From: Contact Centre (CRM) <contact@ribblevalley.gov.uk>
Sent: 26 September 2025 09:35
To: Planning
Subject: Planning Application Comments - 3/2025/0685 FS-Case-752244642

Planning Application Reference No.: [REDACTED]

Address of Development: Field Barn, old Langho road, old Langho, bb6 8aw

Plans and elevations prior to  
conversion

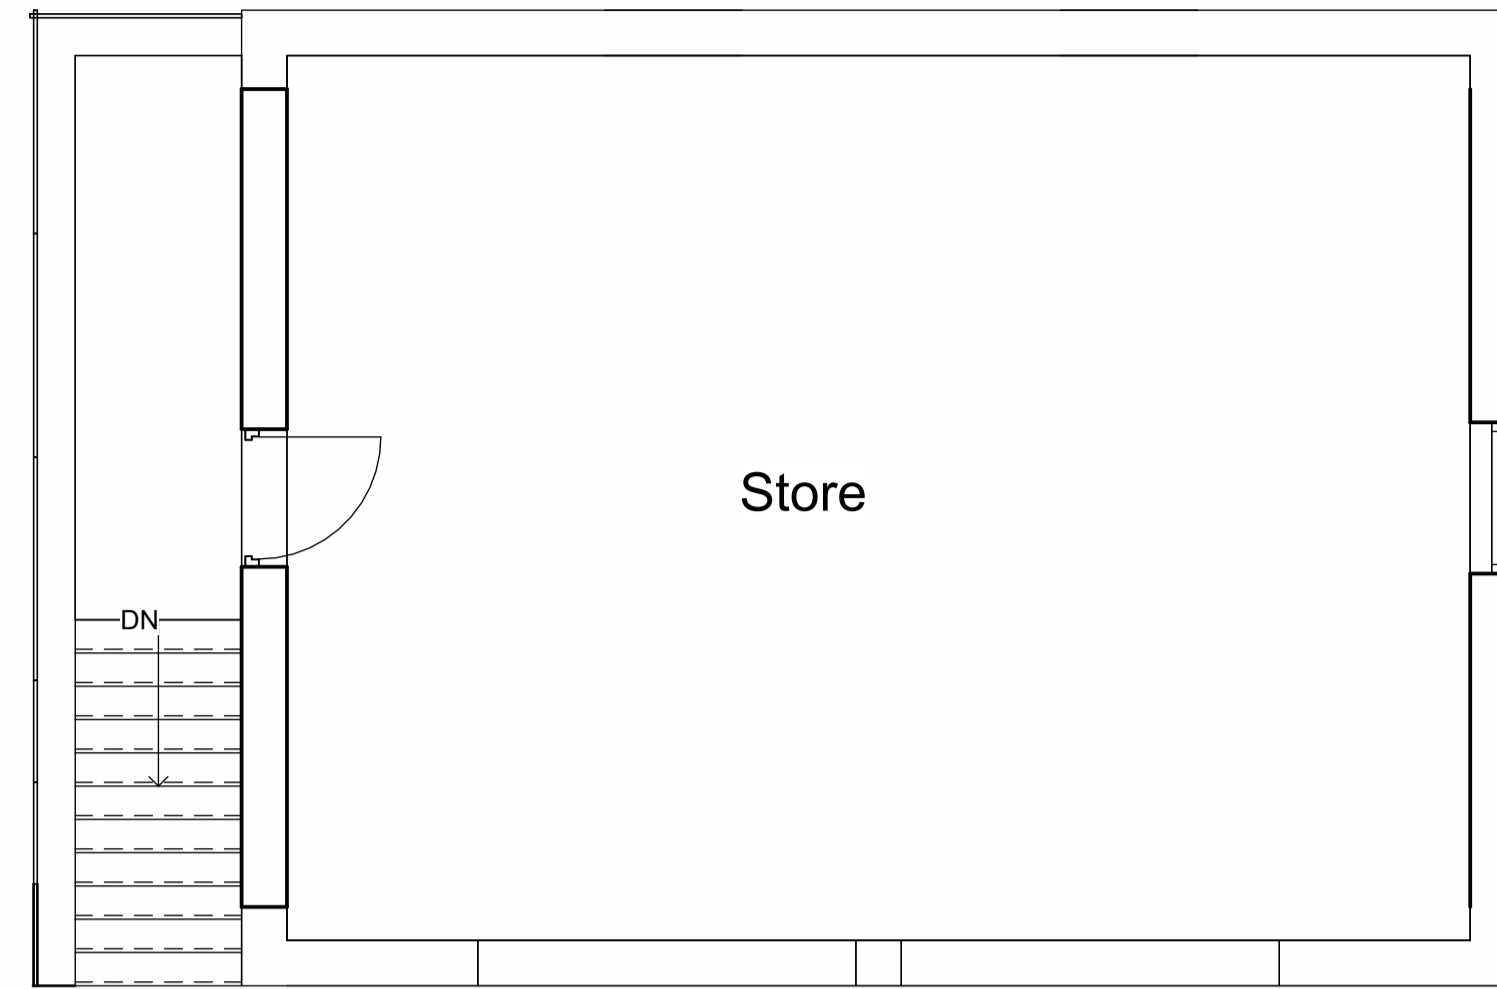
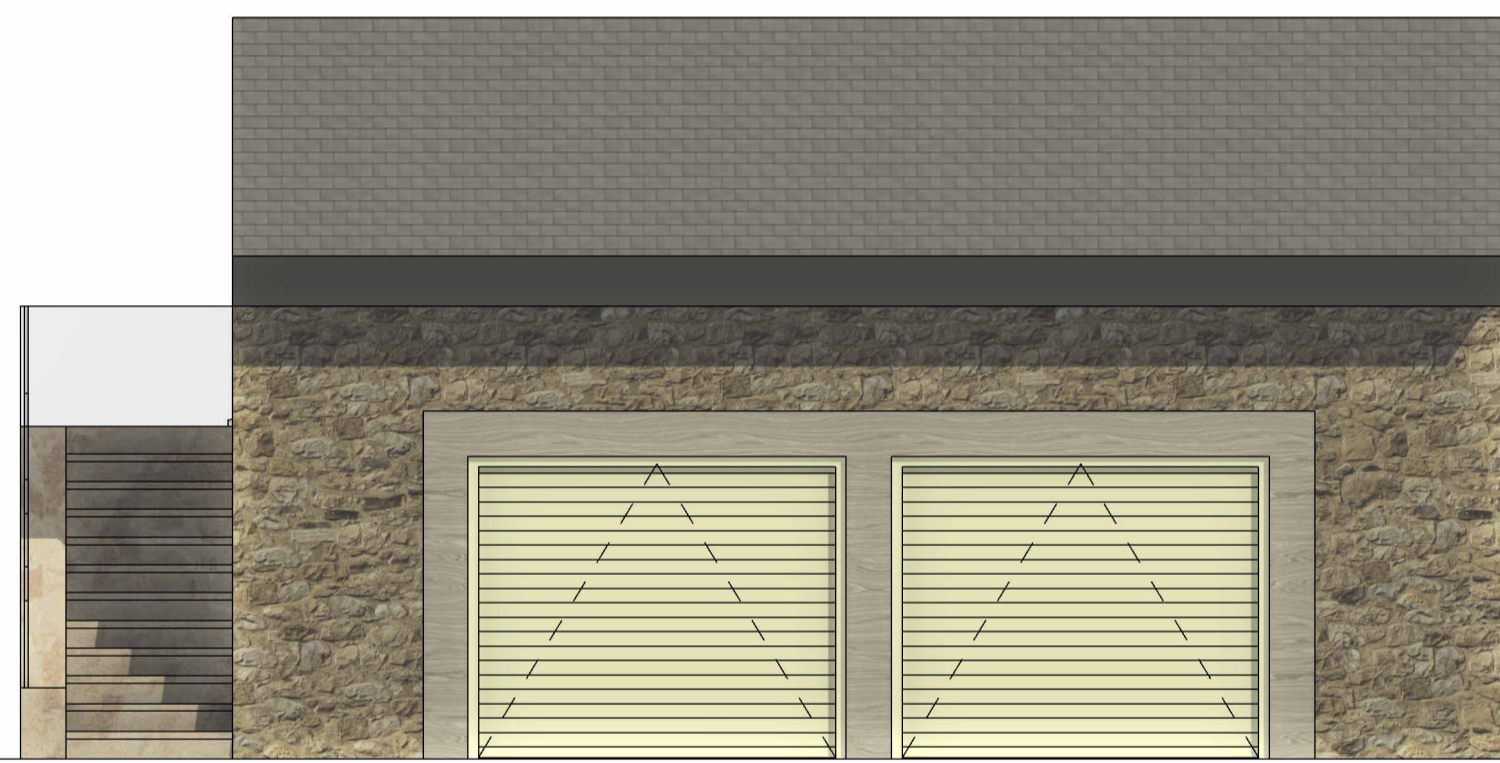
Comments: The information submitted maybe incorrect to the point where it prevents the application from being validated. It is my belief the plan submitted setting on this application and set out as the existing plan of the building is misleading to the extreme. The "existing plan" submitted shows the building is currently a "store" above the garage and this is entirely untrue. The area marked as "store" is currently run as a business holiday let advertised nationally as "deer lodge" and is indeed a fully fitted out area for a self catering holiday let (and is operating as such with customers staying there this week) and not a "store" as the application presents. Indeed this "store" was completed and presented to market at the time the garage was built and had been refused as accommodation on the original application to build the garage. This is a significant abuse of the original planning application and appears to be development by dishonesty and stealth. The owner showed zero respect for the planning process and can't use the excuse that they didn't know they had broken the planning laws, but in building this accommodation atop the garage they had been fully aware it was refused. Do they believe themselves to be above the planning rules?
